Fw: FP/70/26/HHH 5 Limmer Lane - sub plans

From: Nick Hebde [REDACTED]
Sent: 06 July 2026 13:48
To: Rhiannon Lloyd <Rhiannon.Lloyd@arun.gov.uk>
Subject: Re: FP/70/26/HHH 5 Limmer Lane

Drawing file: FP_70_26_HH / 2126 3.001 Rev 01 Site Plan.pdf

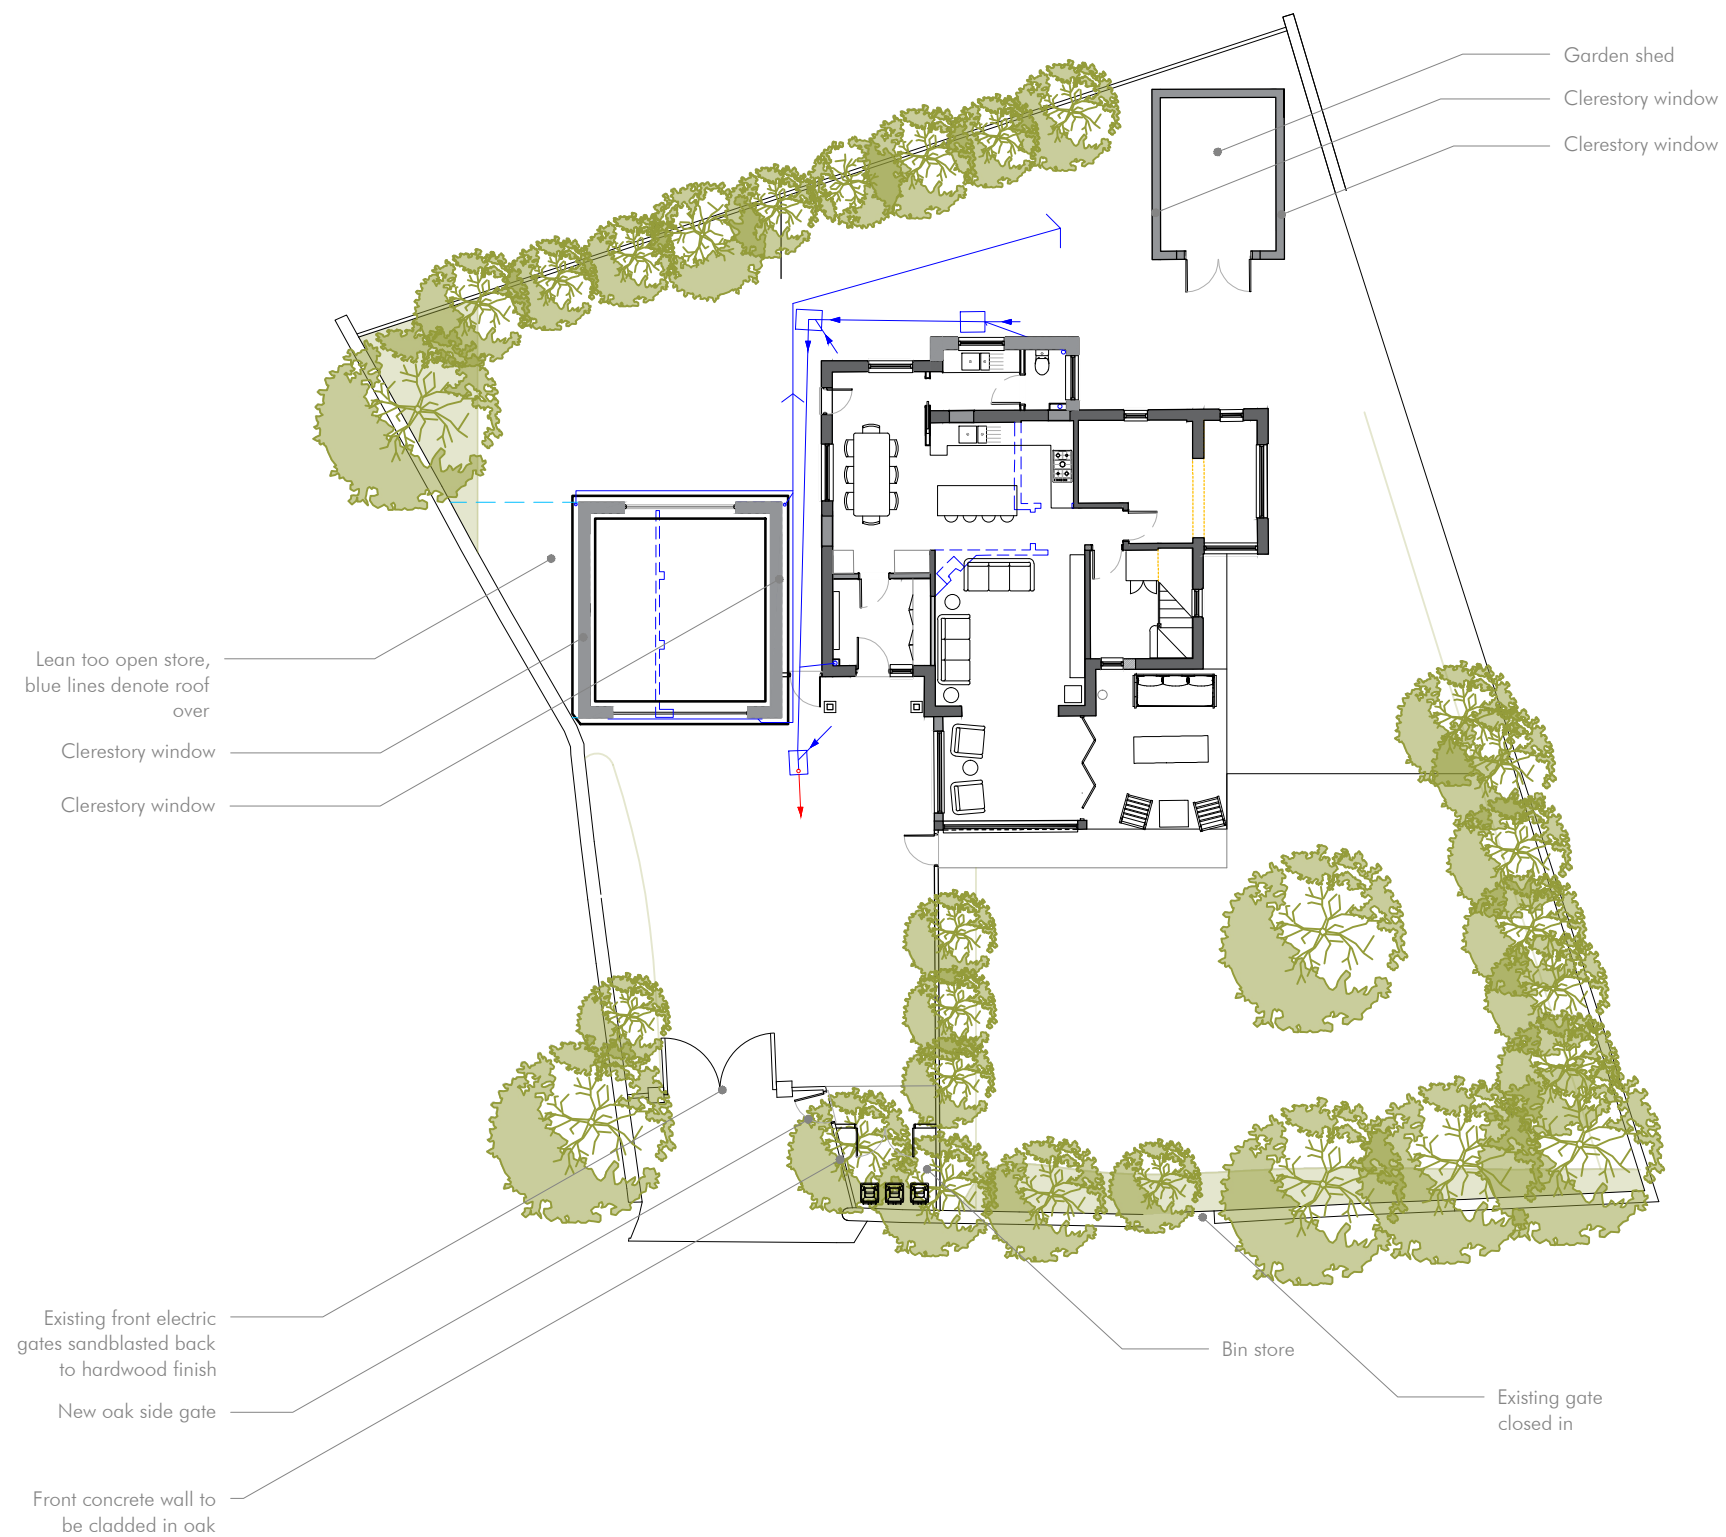
A lean-to open store with a roof is annotated on the site plan but is not depicted on the elevations. Please amend.

Ass attched updated documents.

Drawing
Proposed Ground Floor Plan

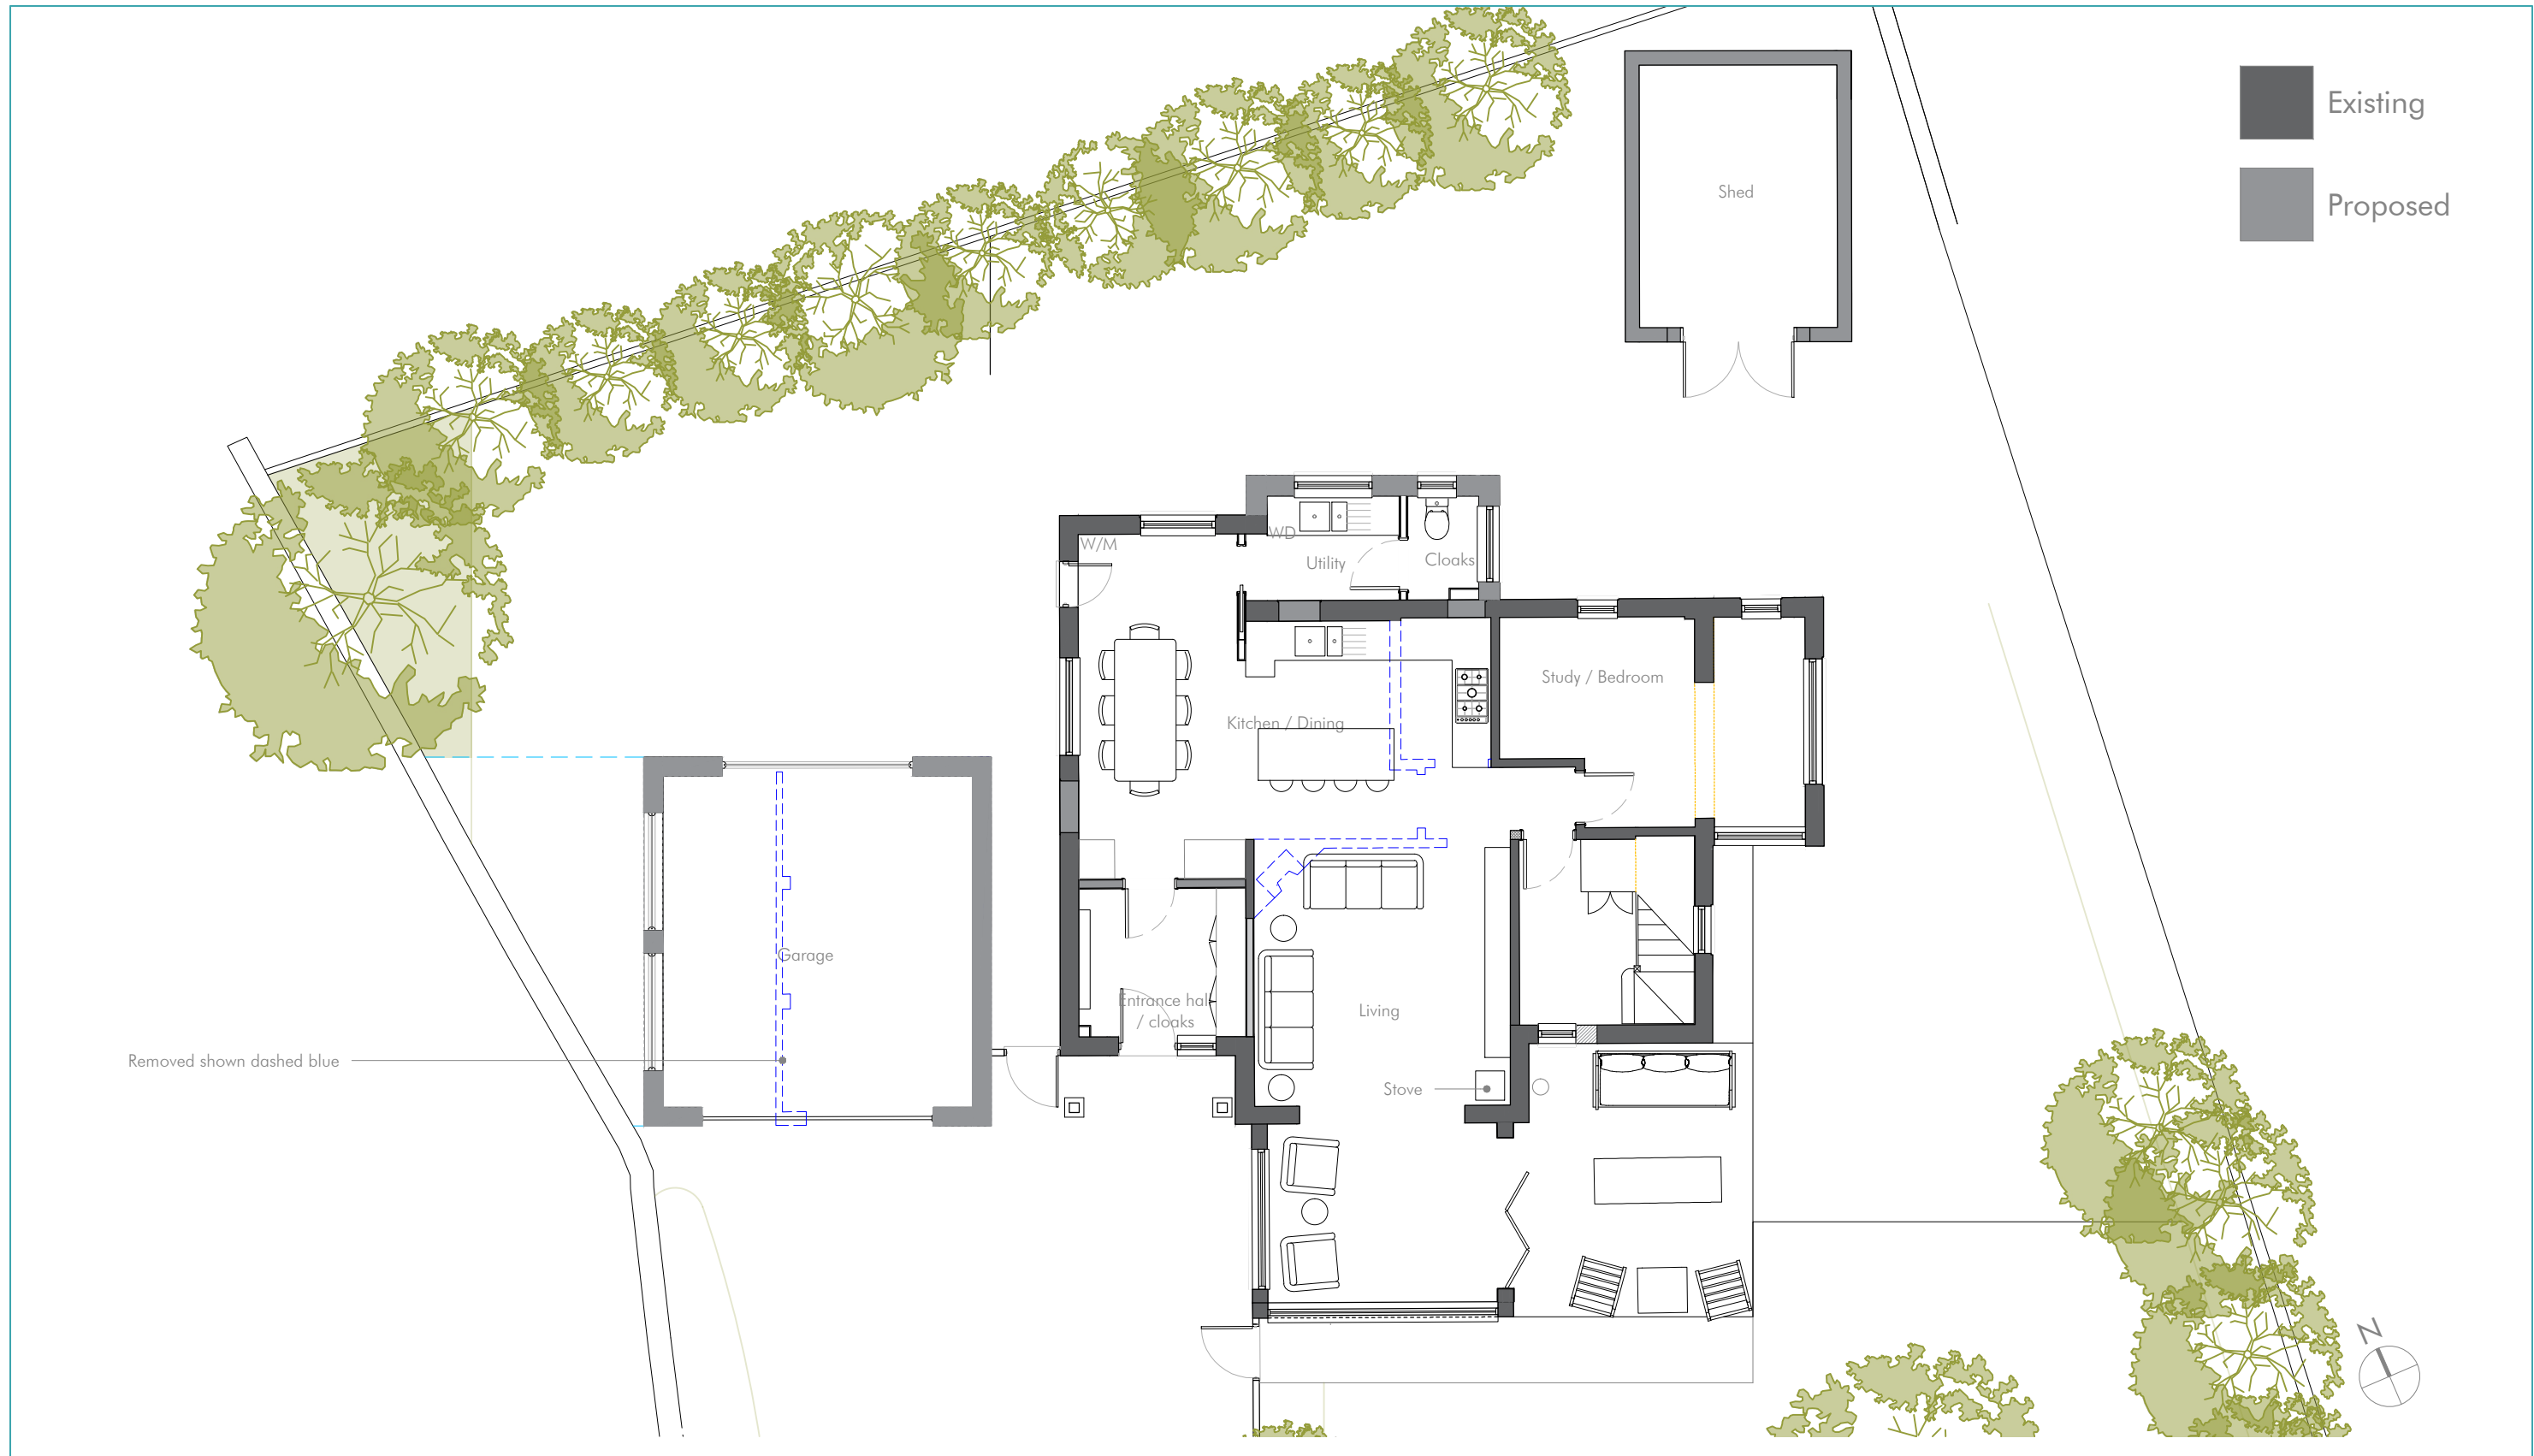
A single-storey rear extension is proposed within the plans but is not mentioned in the description. Please confirm whether the rear extension should be included within the description.

Yes

Drawing
Proposed South & North Elevations

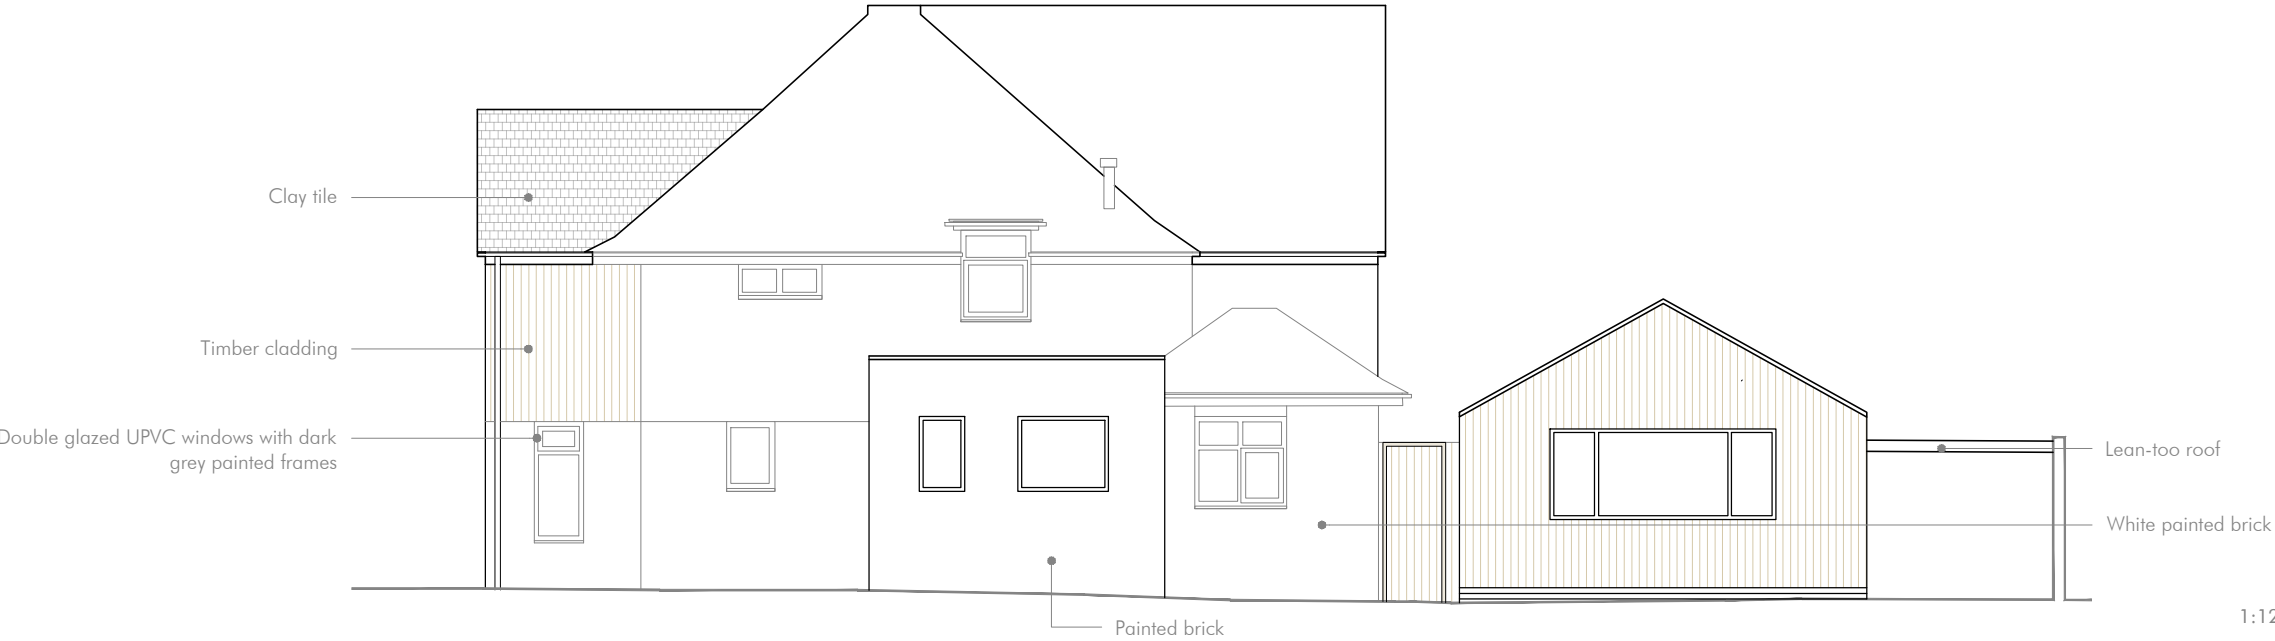
Finally, I note that the proposed garage roof would be very high at 5m maximum height. This is only 0.2m below the top of the first-floor windows on the west elevation. Ideally, we would seek amendments to reduce the height.

The garage is less than 4m high, I have updated the east and west elevations to suit.
